Variation of condition 2 granted under BE/10/50/Q to allow the caravan site to be operated for up to a 12 month period & occupied solely for holiday purposes only & shall not be occupied as a person's sole or main place of residence.

Variation of condition 2 granted under BE/10/50/Q to allow the eastern part of the caravan site to be operated over a 12 month period and the remainder of the site to be occupied for 10 months between the 1st March and 2nd January. The occupation of caravans shall be solely for holiday purposes only & shall not be occupied as a person's sole or main place of residence.

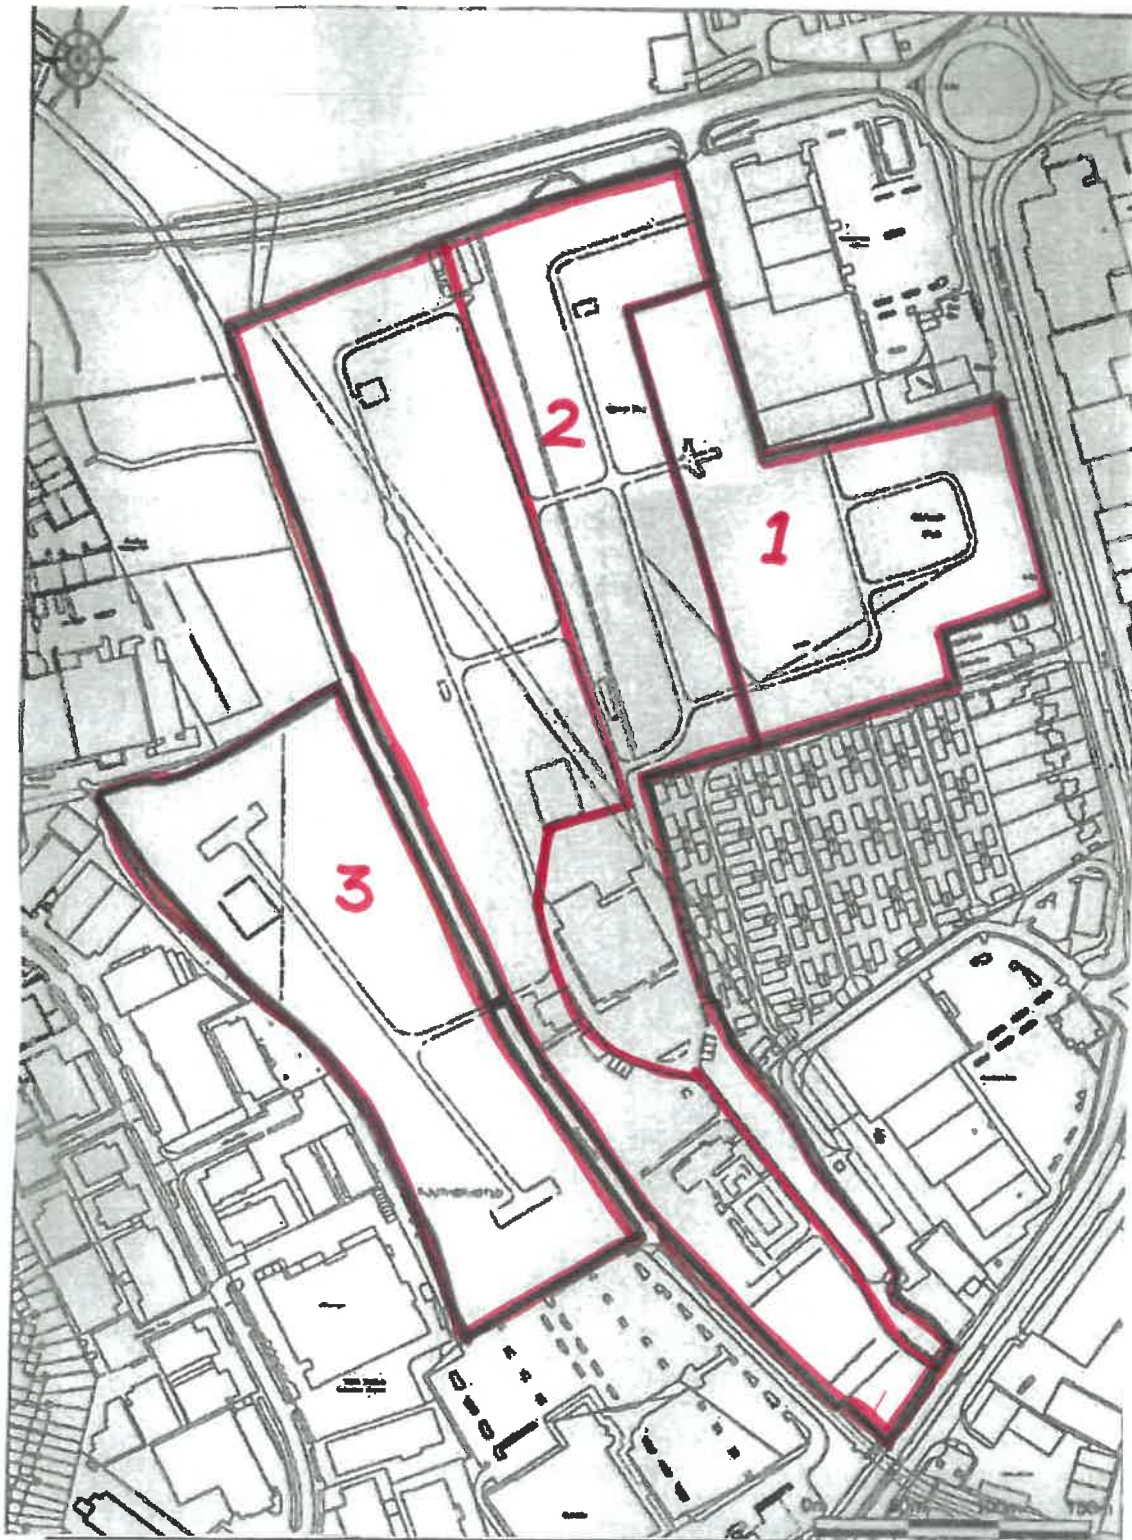
I've been updated by my line manager to amend the red edge of the application to include only the areas of the site which will seek the extended 12 month period. From recollection some of the areas are operating within the 10 month period and would remain unaffected and can therefore be excluded from the red edge.

1. Could you provide a revised site plan so the red line solely relates to the area to be extended to a 12 month occupation?
2. Could you confirm the change of description of development to the following is acceptable:

The applicant is content for the eastern part of the site to remain to be used for 12 months with the rest used for 10 months between 1st March and 2nd January each year in accordance with the request of the EA to allow a permission.
